Re: Planning Application 20/0449

Address: Plot 2 8 Hammond Drive Read BB12 7RE

Description: Variation of condition 2 to allow variation to size of approved garage for plot 2 from application number 3/2019/1032.

Plot 2
Floor Plans

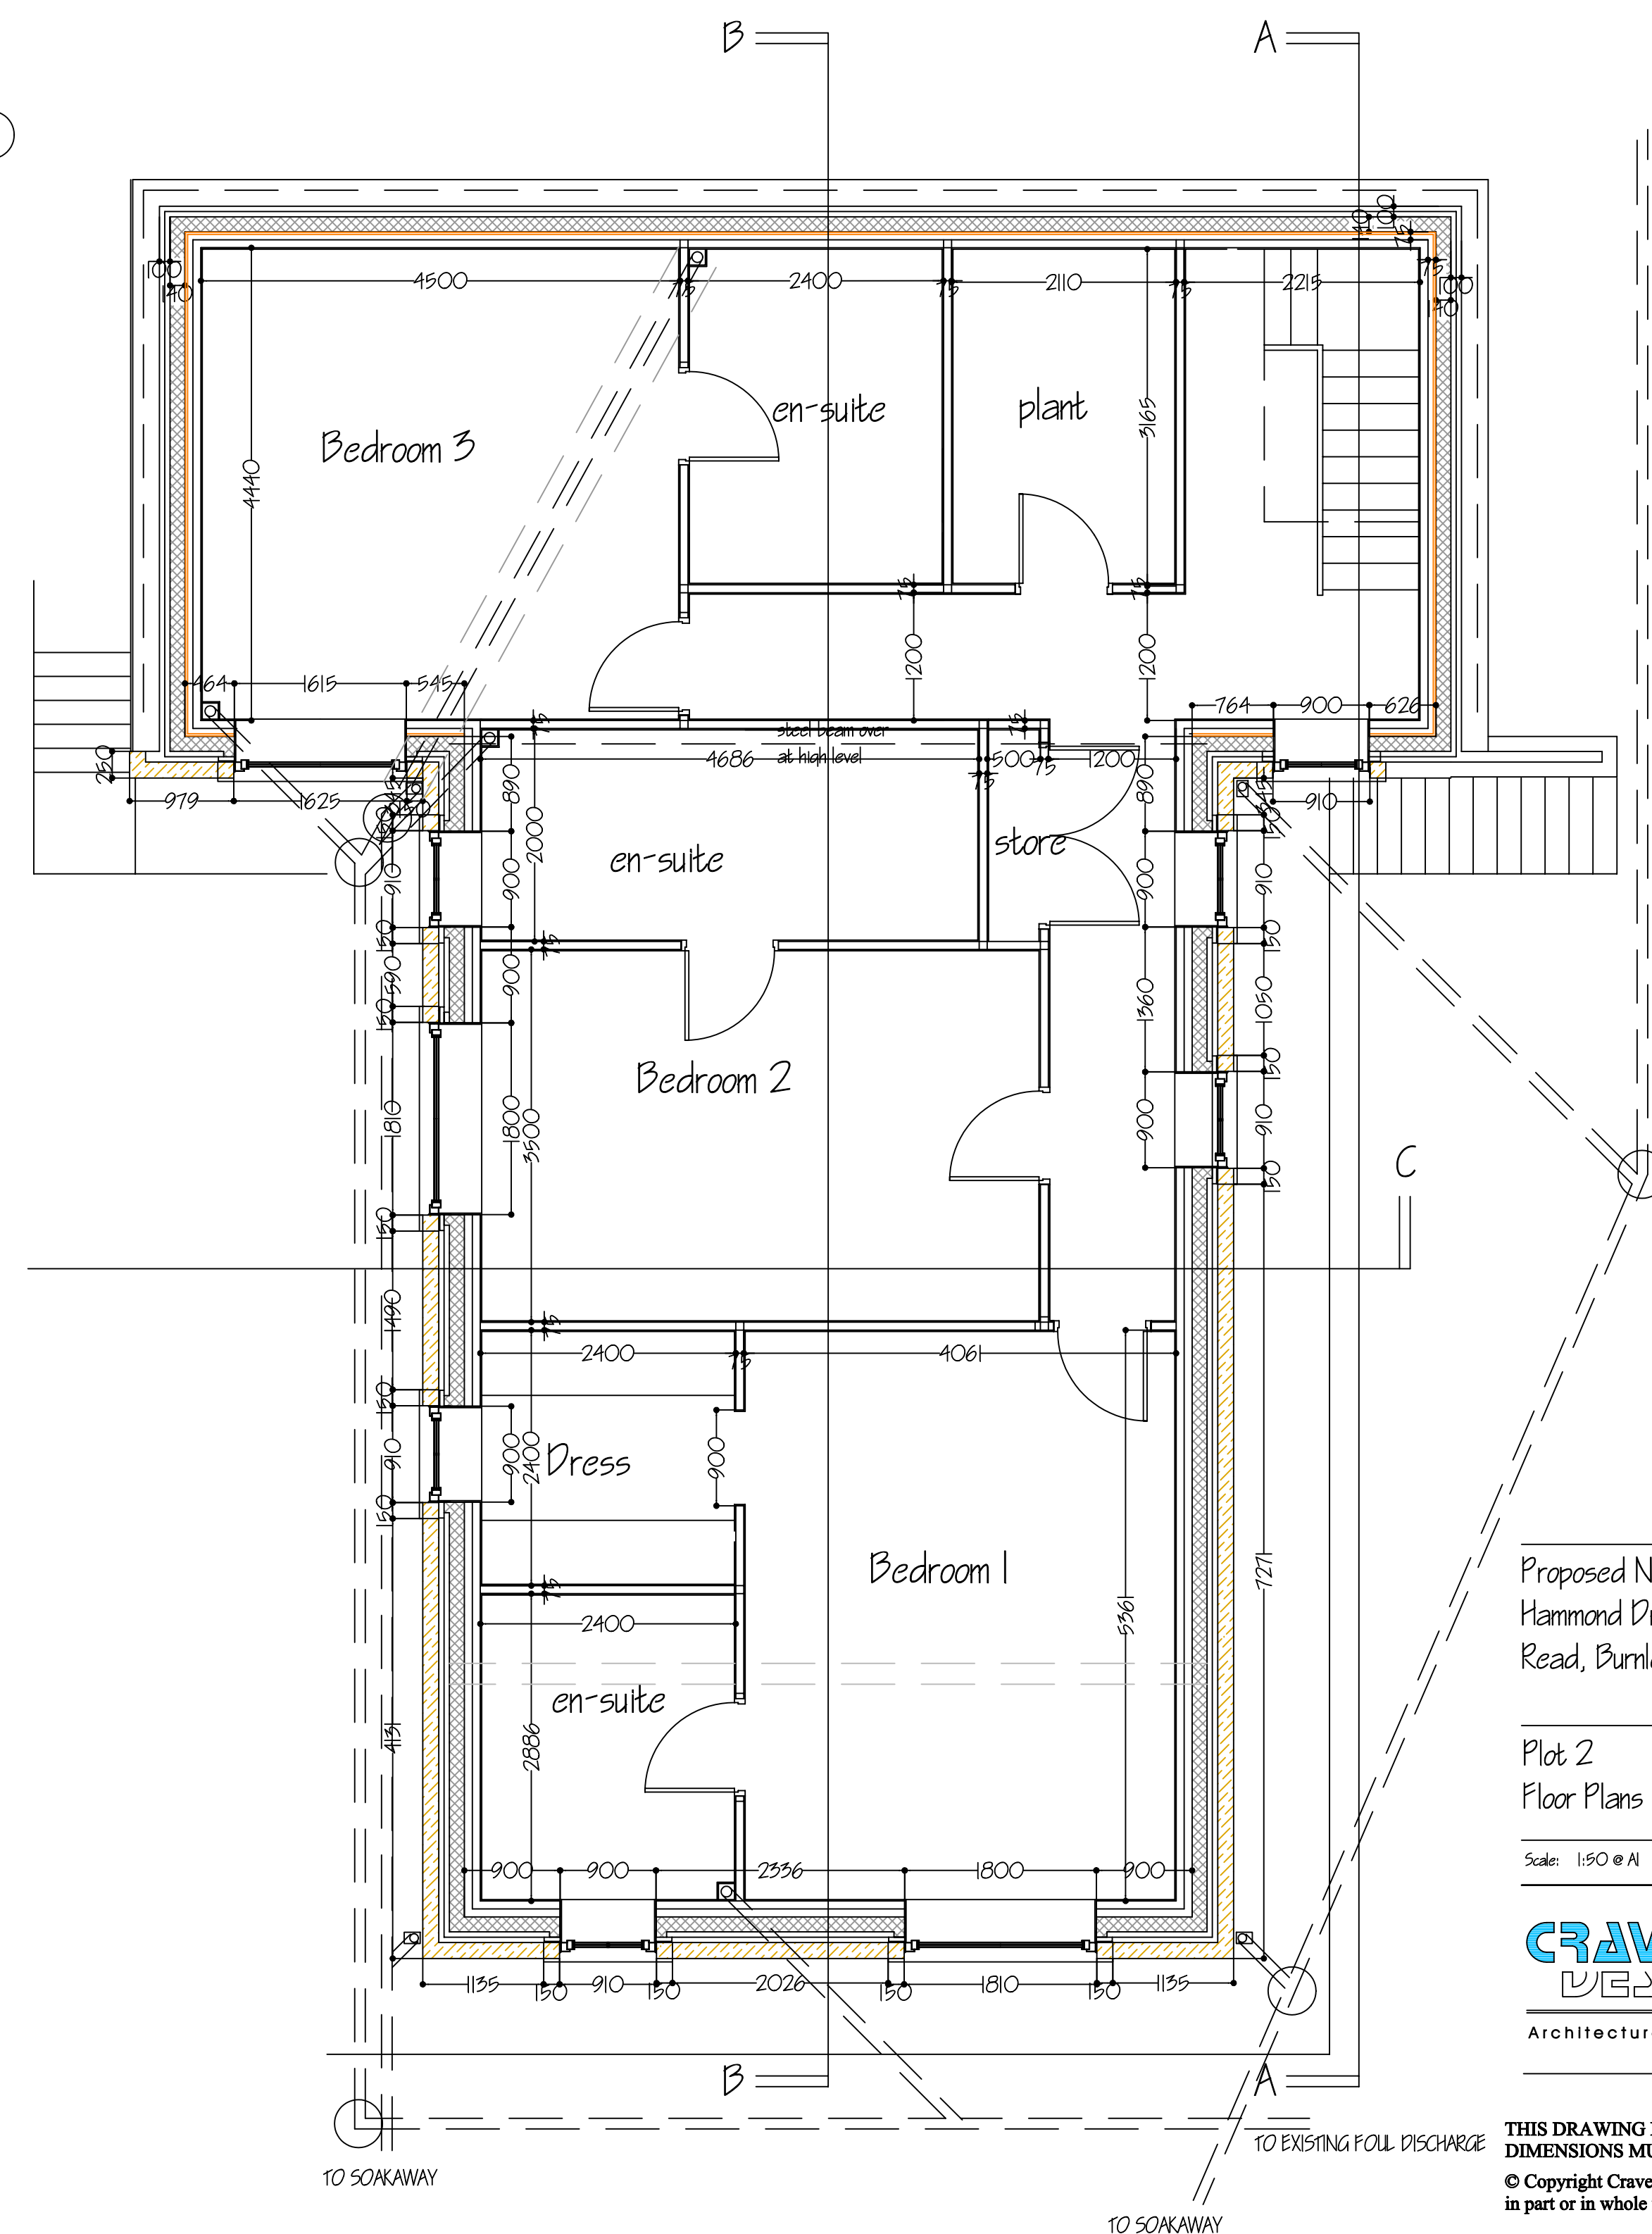
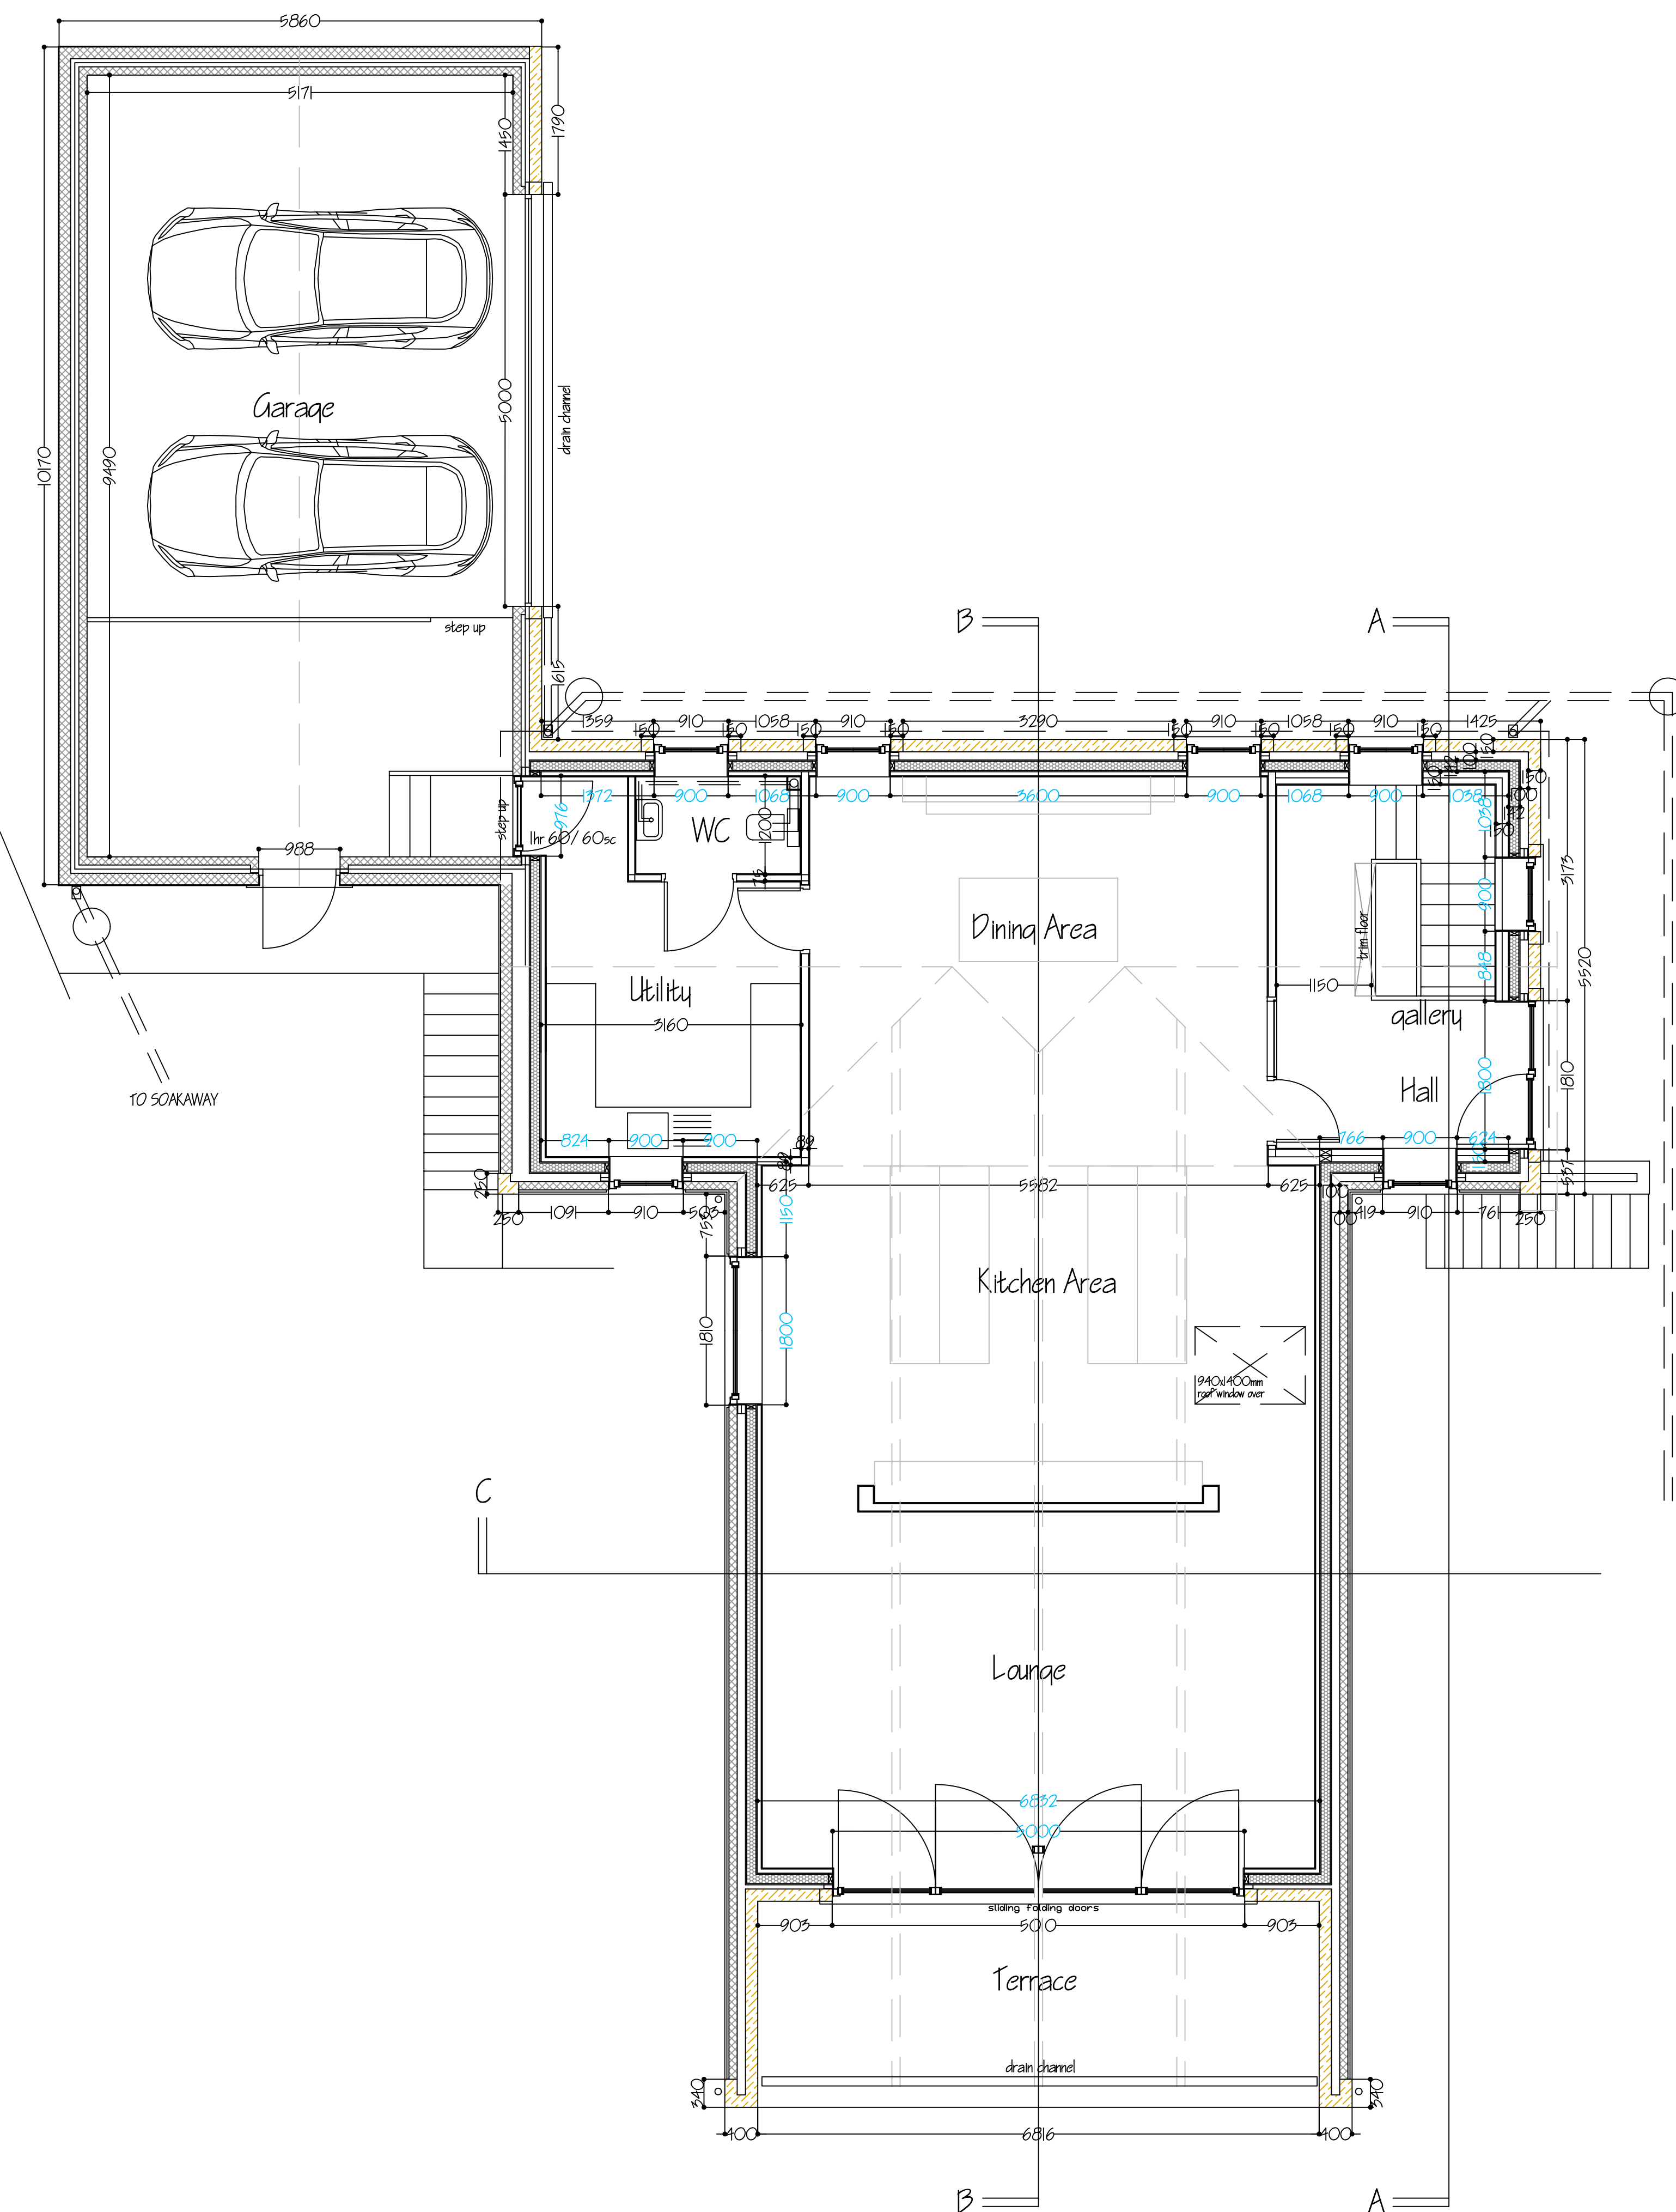
It is noted that the garage is shorter than would be expected however there is sufficient length to allow for a large family car to be parked in the garage and an increased width.
